**Planning Department
Transportation Development Services Section**

**Re: Albuquerque Heights Seventh Day Adventist Church,
4920 Wyoming Blvd NE
Certification Submittal for Certificate of Occupancy – Transportation
Development
Engineer's Stamp dated 6-22-13 (F20-D021)
Certification dated 4-07-14**

The Letter of Certification submitted on 04-07-14 is not sufficient for acceptance by this office for final Certificate of Occupancy (C.O.). The following items need to be addressed:

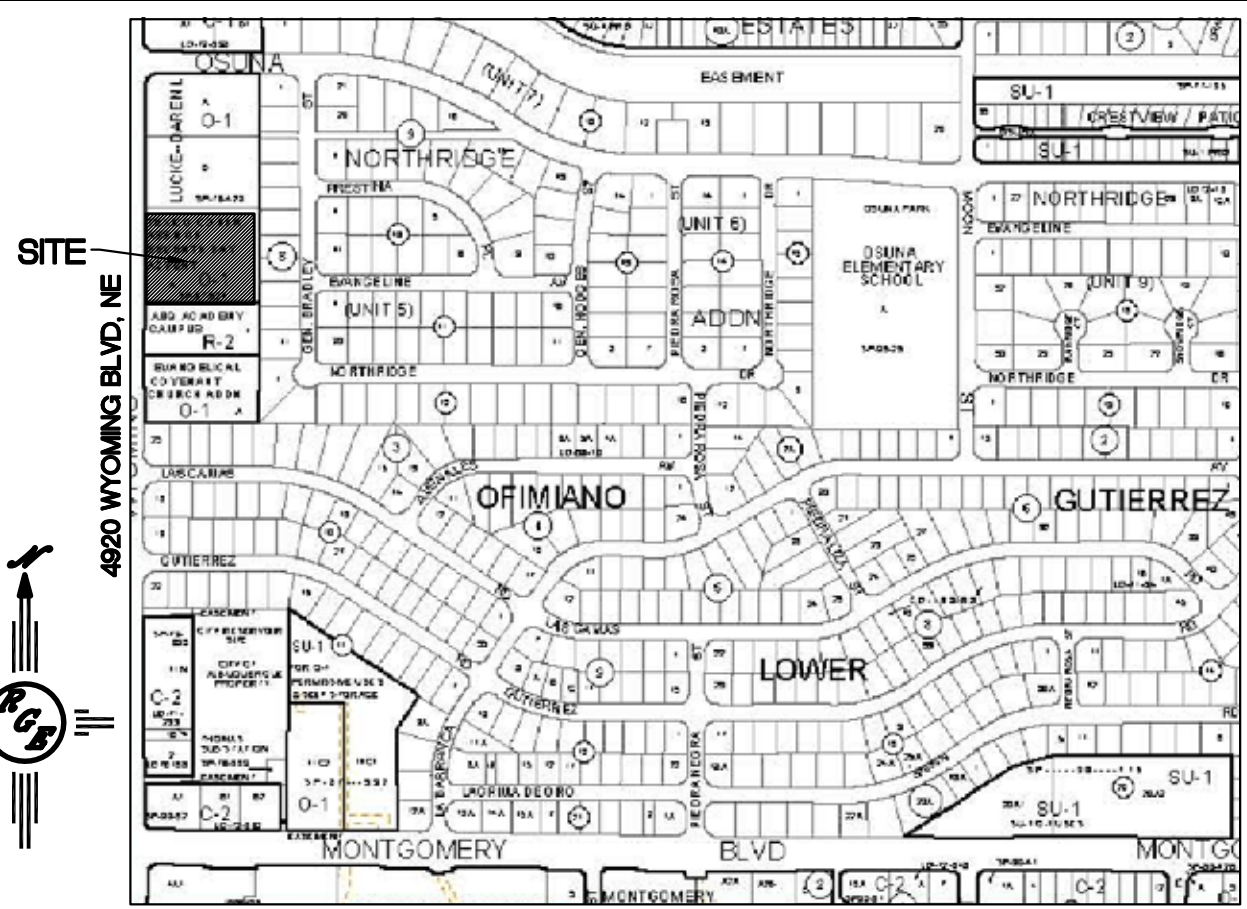
- The grade change at the pedestrian walkway from the right-of-way on Wyoming Blvd exceeds the maximum slope allowed. We suggest adding a landing to the pedestrian walkway to meet the minimum slope allowed.
